10 DEC 2019.

I am objecting to application FG/141/19/PL. This proposal bares little difference to the previous application, in size, squashed into space, visual obstruction, danger of open pond and aesthetically defaced view of Tamarisk way.

**PROPOSED ROOF PLAN AND
PROPOSED ELEVATIONS
(PROPOSED NEW DWELLING)**

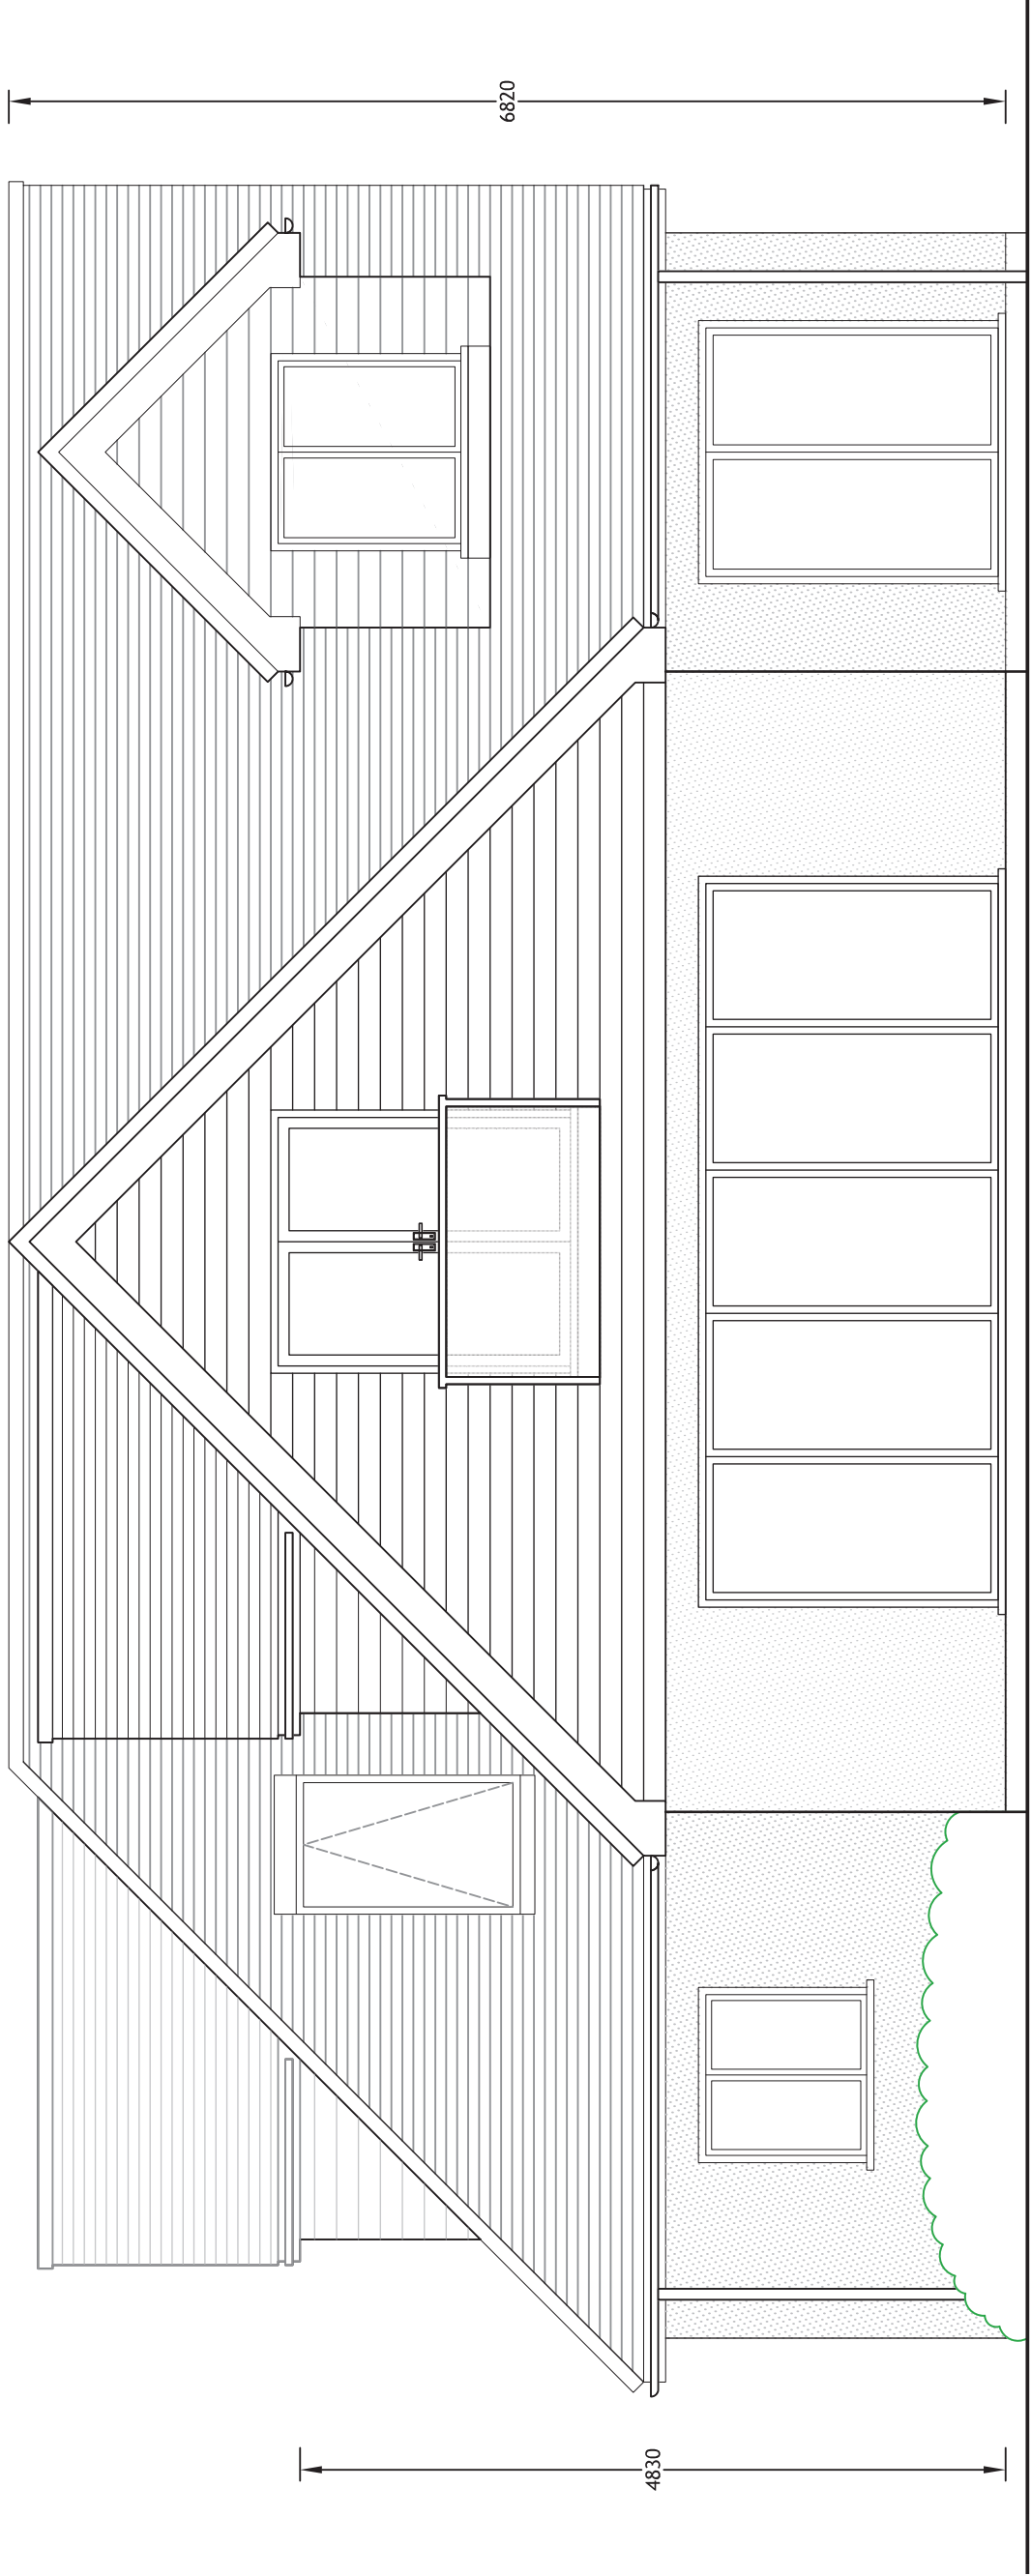
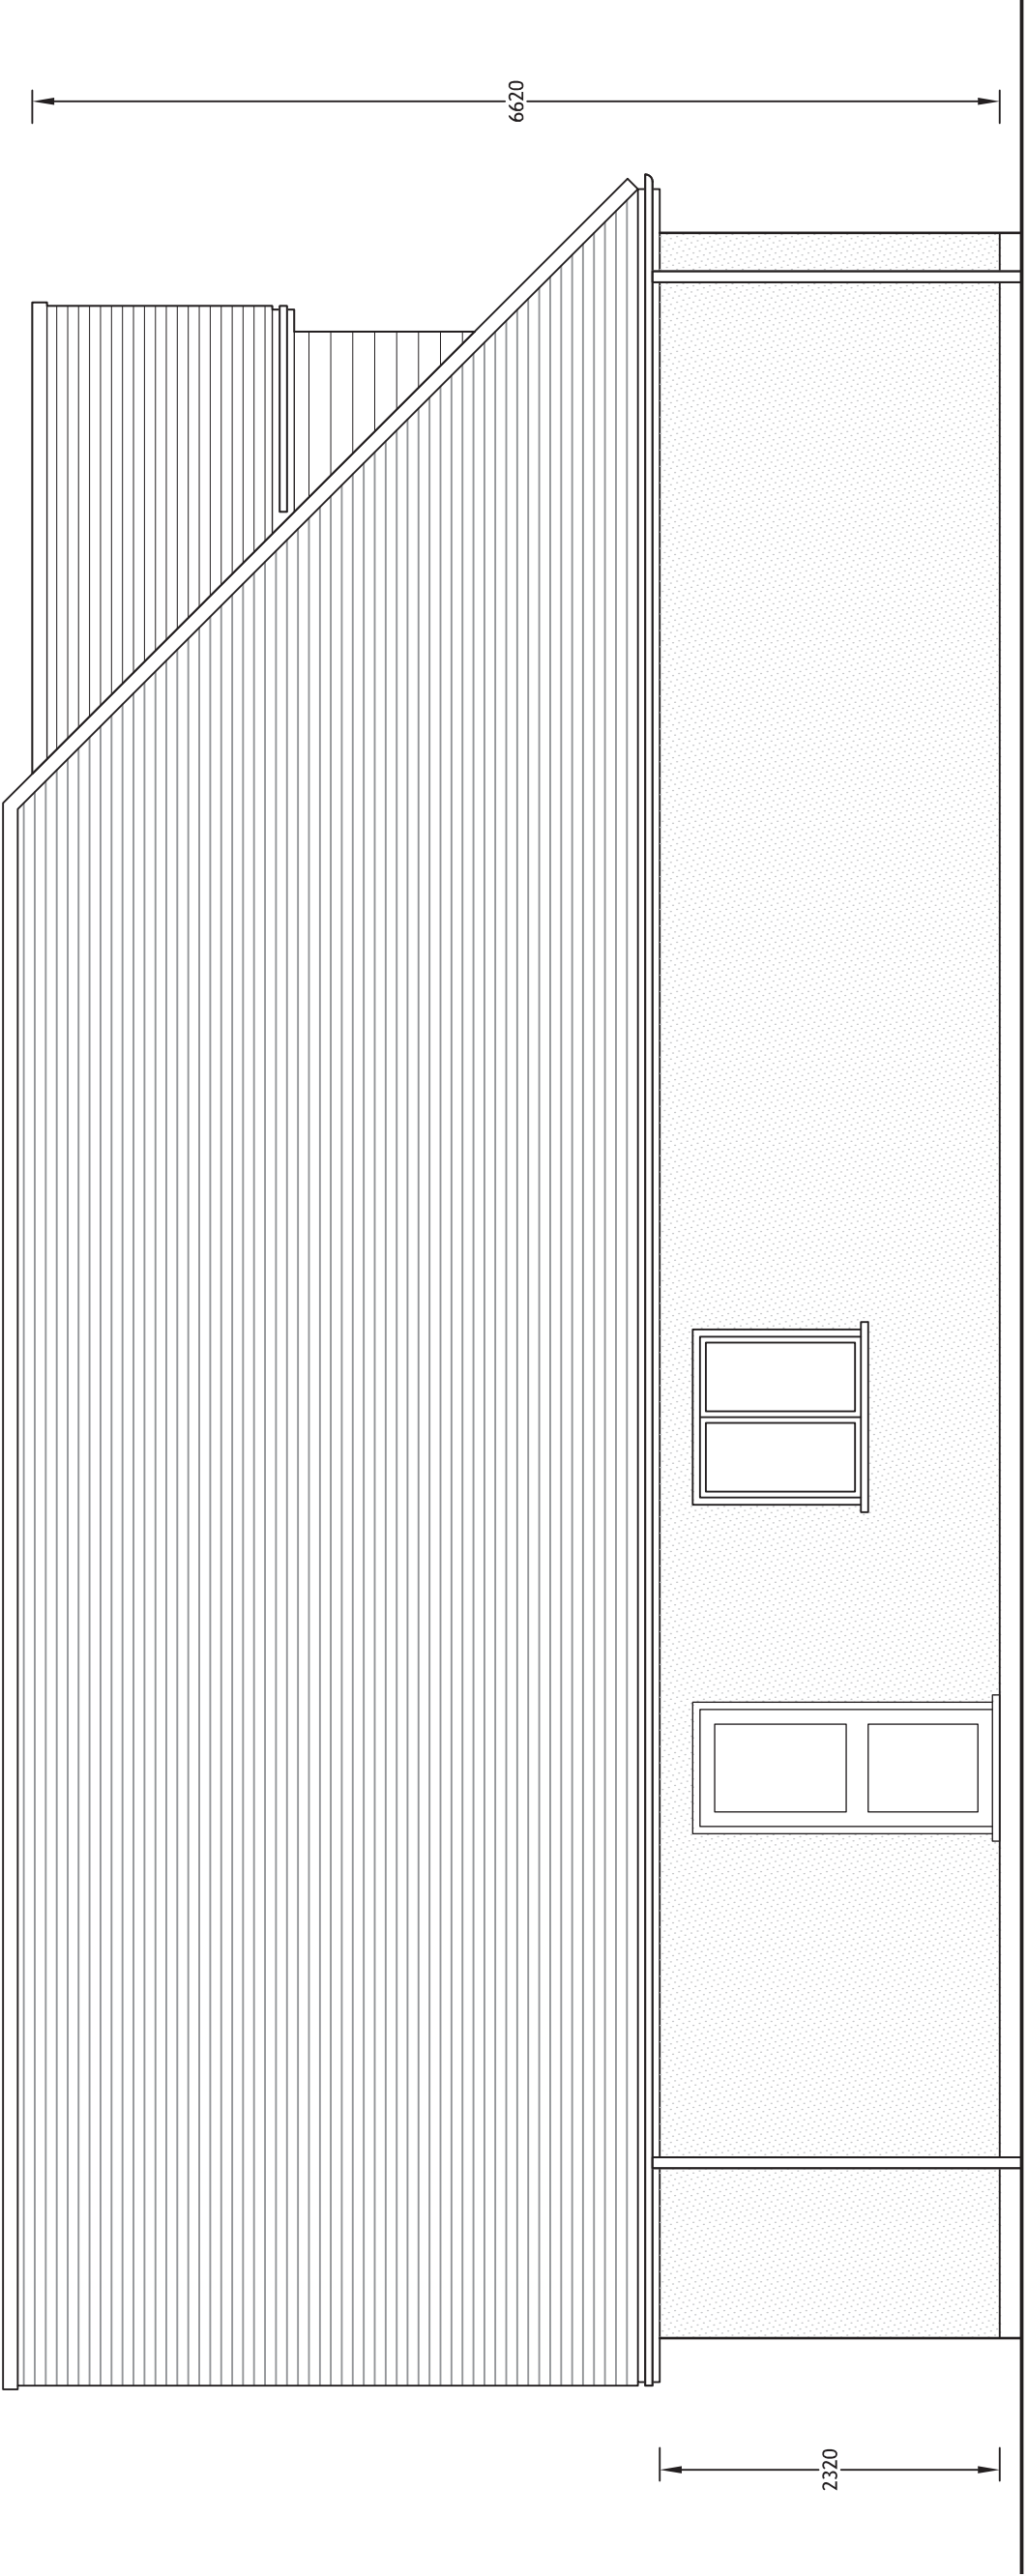
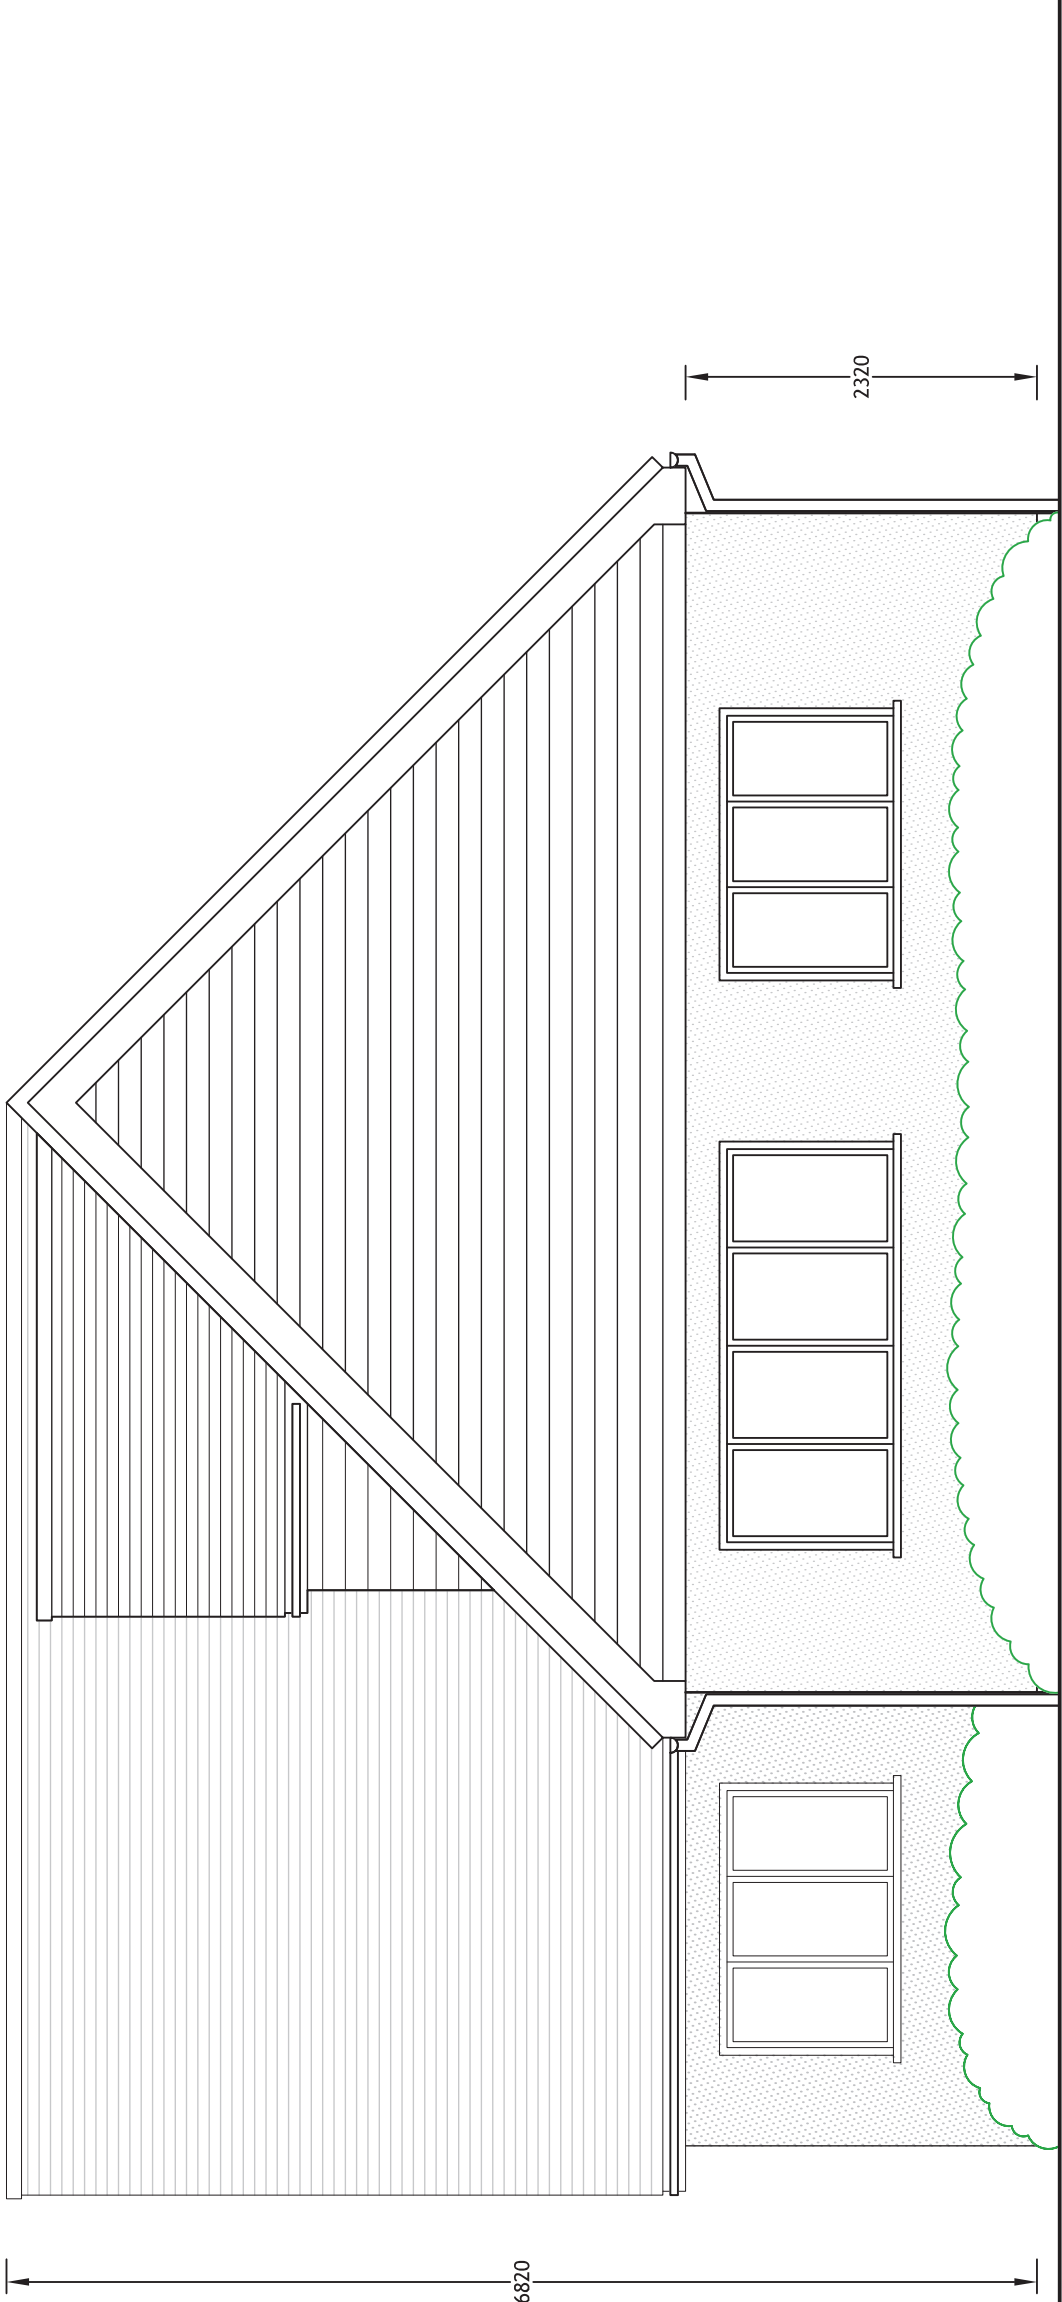
The new proposal changes the windows so as not to overlook neighbours property by use of opaque glass (No vision from either side of glass). If one-sided glass is used this can accidently be installed the wrong way on ~~reversed~~ reversed at a later date.
